**DRB Comments**

**PROJECT # 1008165**

**RE: Tract C-2, South Broadway Industrial Acres and Tracts B-1 and B-2, Lands of Schultz**

PLAT OF
TRACT B-C-1,
SOUTH BROADWAY INDUSTRIAL ACRES

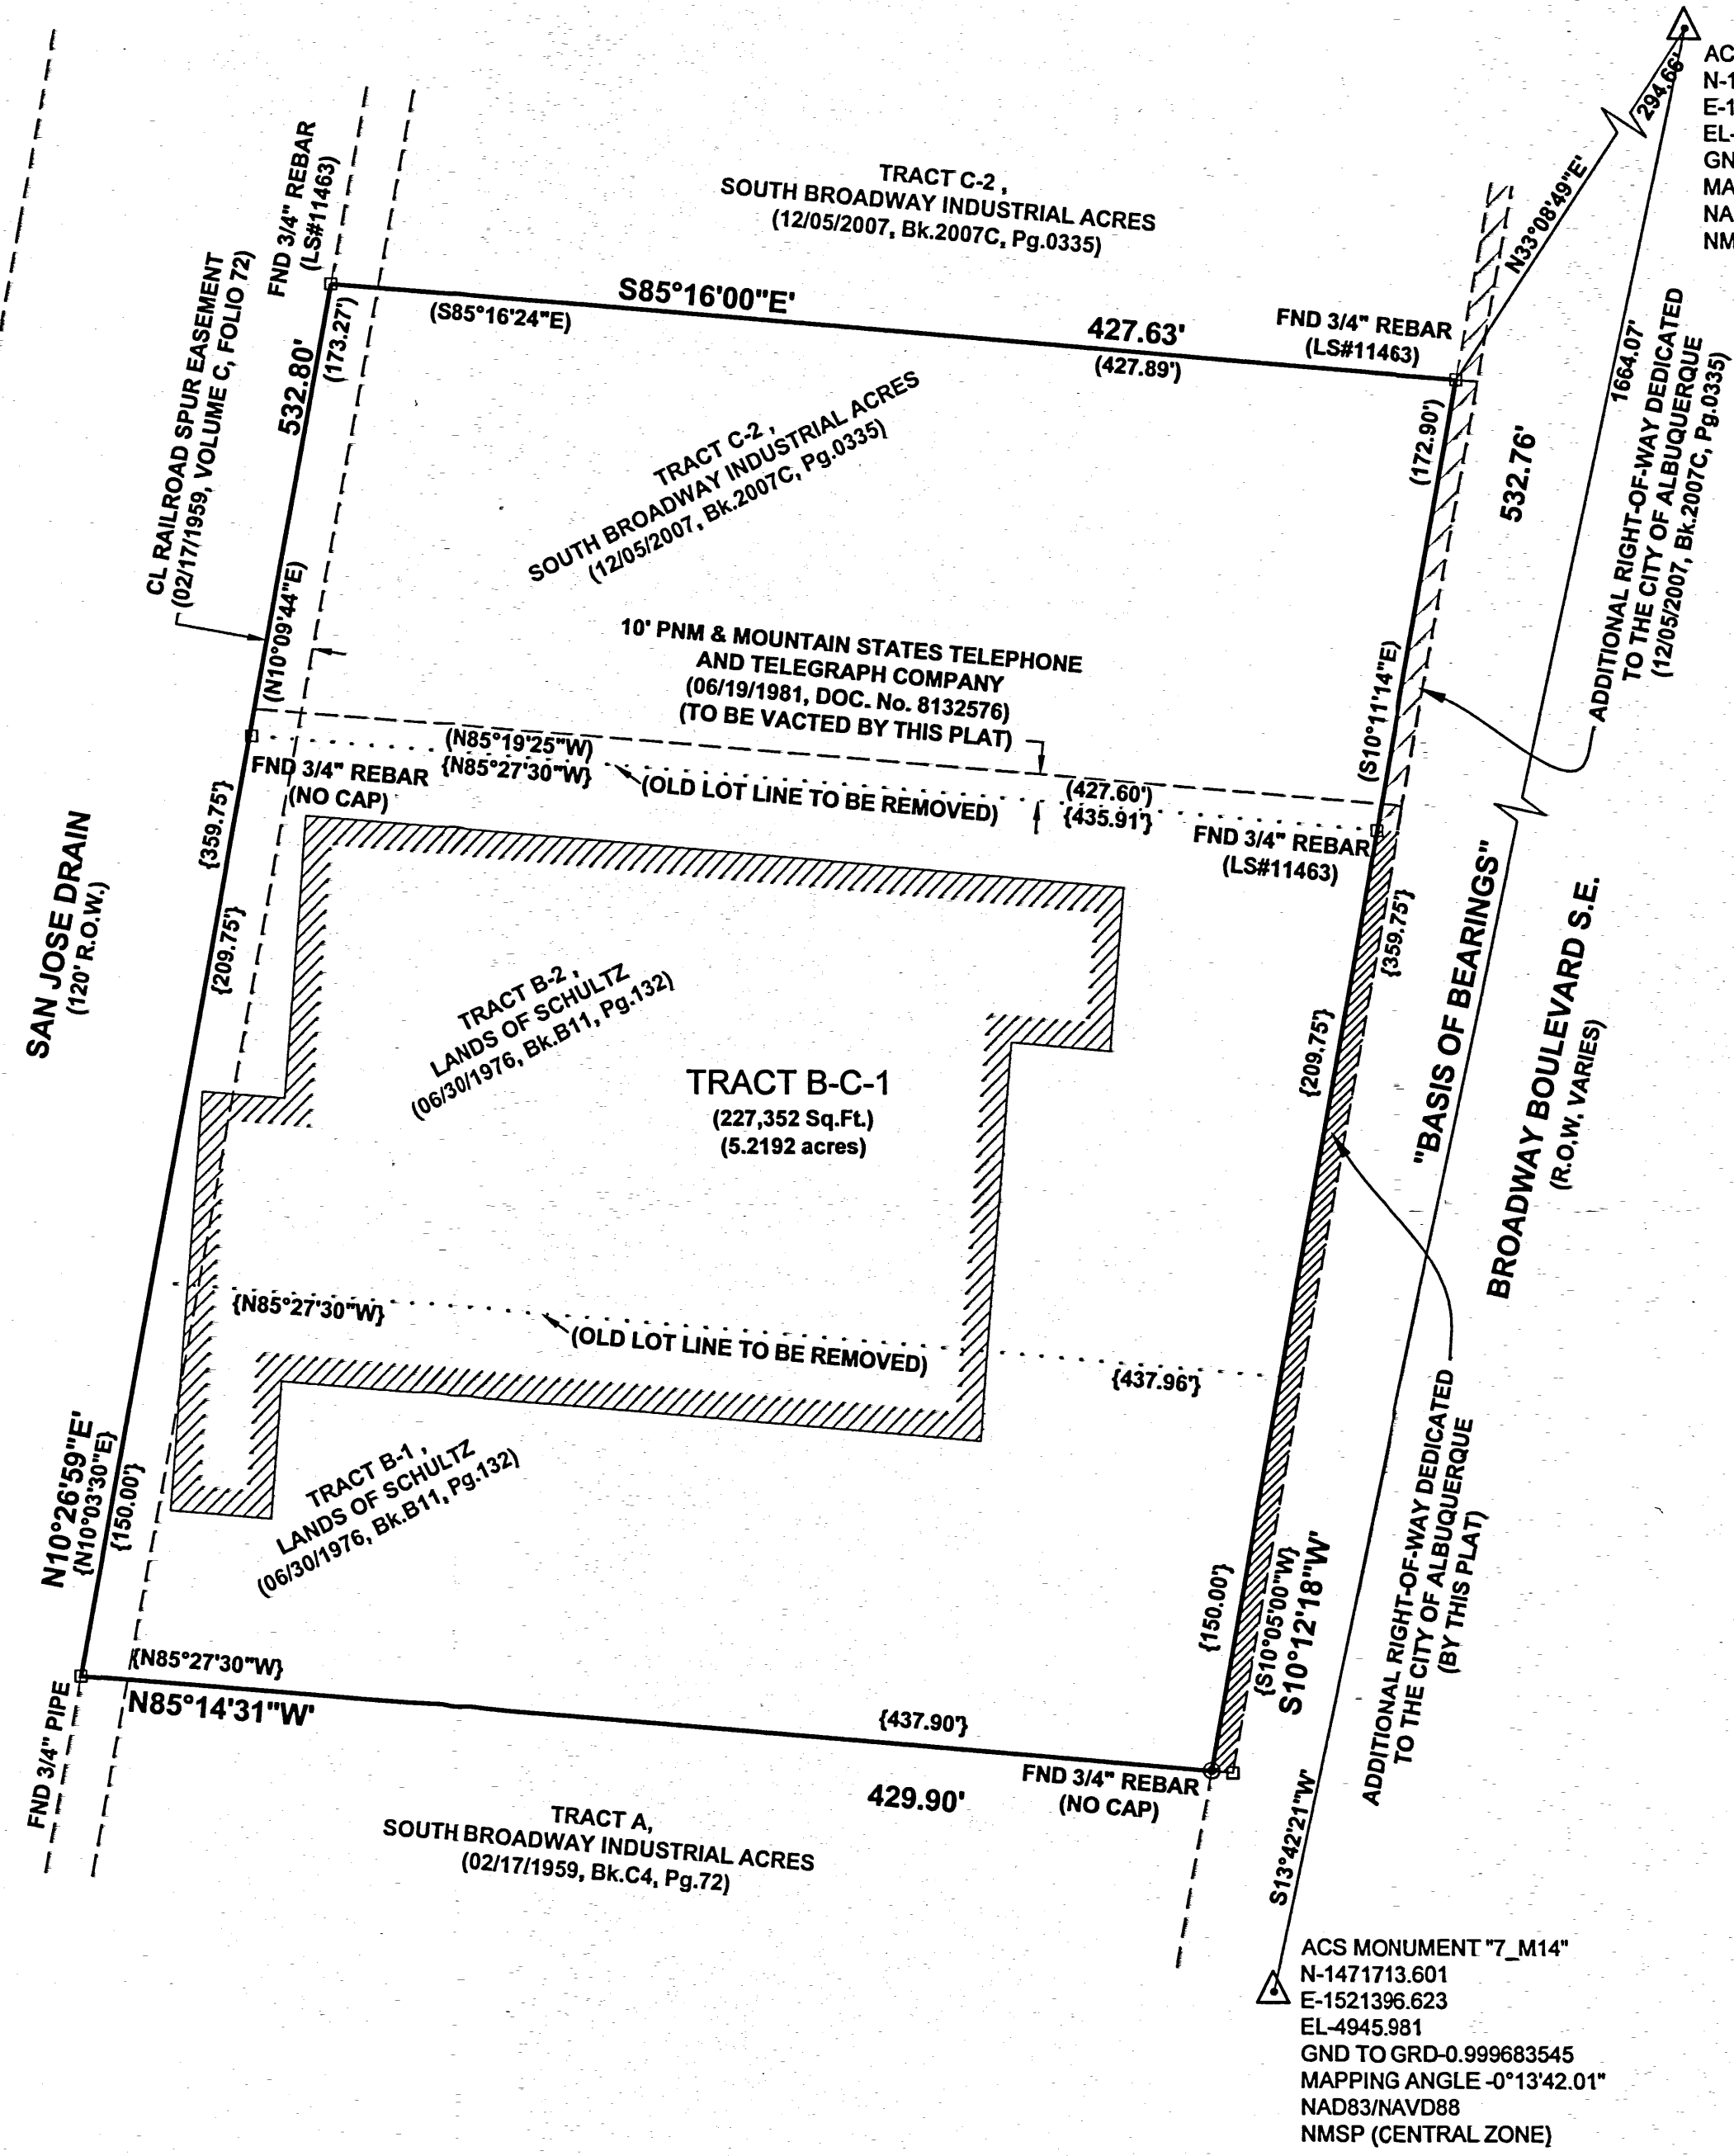
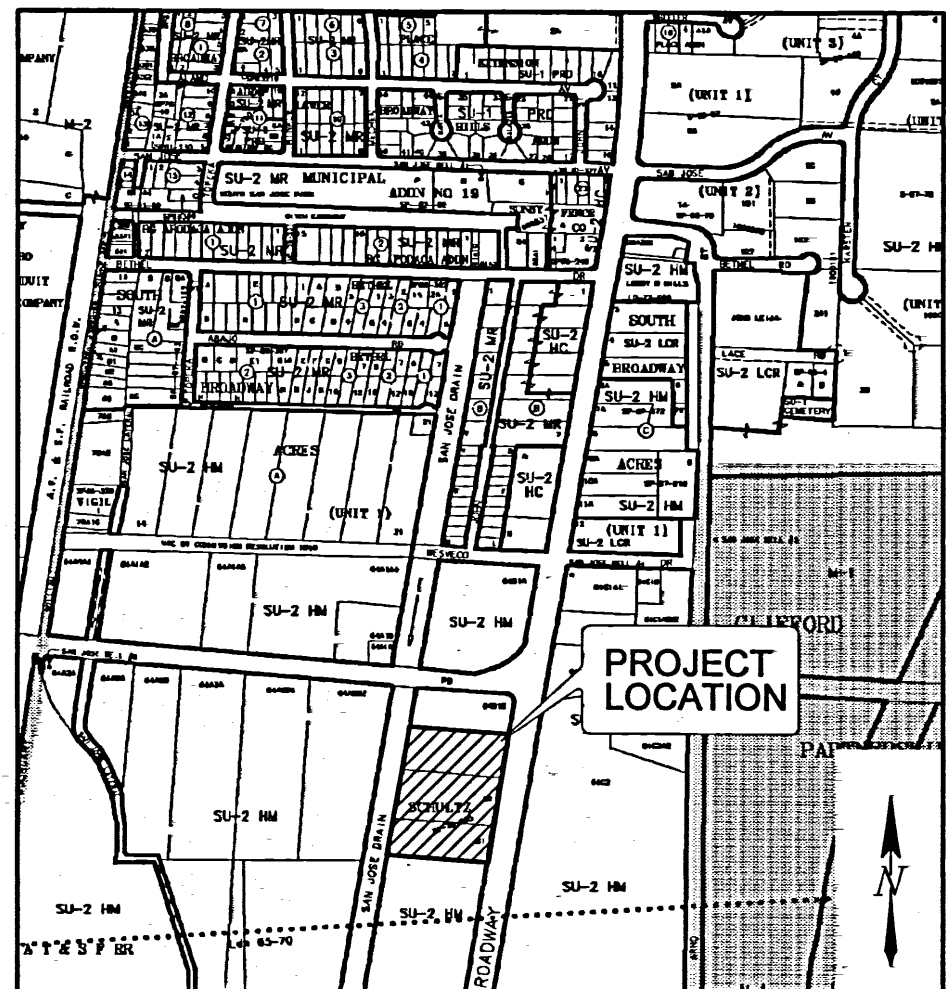
Vacation of the 10 foot PNM and MST&T Easement will require written concurrence from PNM and Qwest at the time of Preliminary and Final Plat submittal, or else an advertised Public Hearing would be required.

A Solar Note consistent with § 14-14-4-7 of the Subdivision Ordinance is required, specific to this type of request, i.e. use the words "THIS PLAT" (rather than the words "REQUESTED FINAL ACTION") at the beginning of the note, and do not use the words "OR SITE DEVELOPMENT PLAN FOR SUBDIVISION" at the end of the note.

Based on the 2008 aerial photograph, there appears to be a structure on existing Tract C-2; if so, please show on site sketch to demonstrate minimum setback from property line.
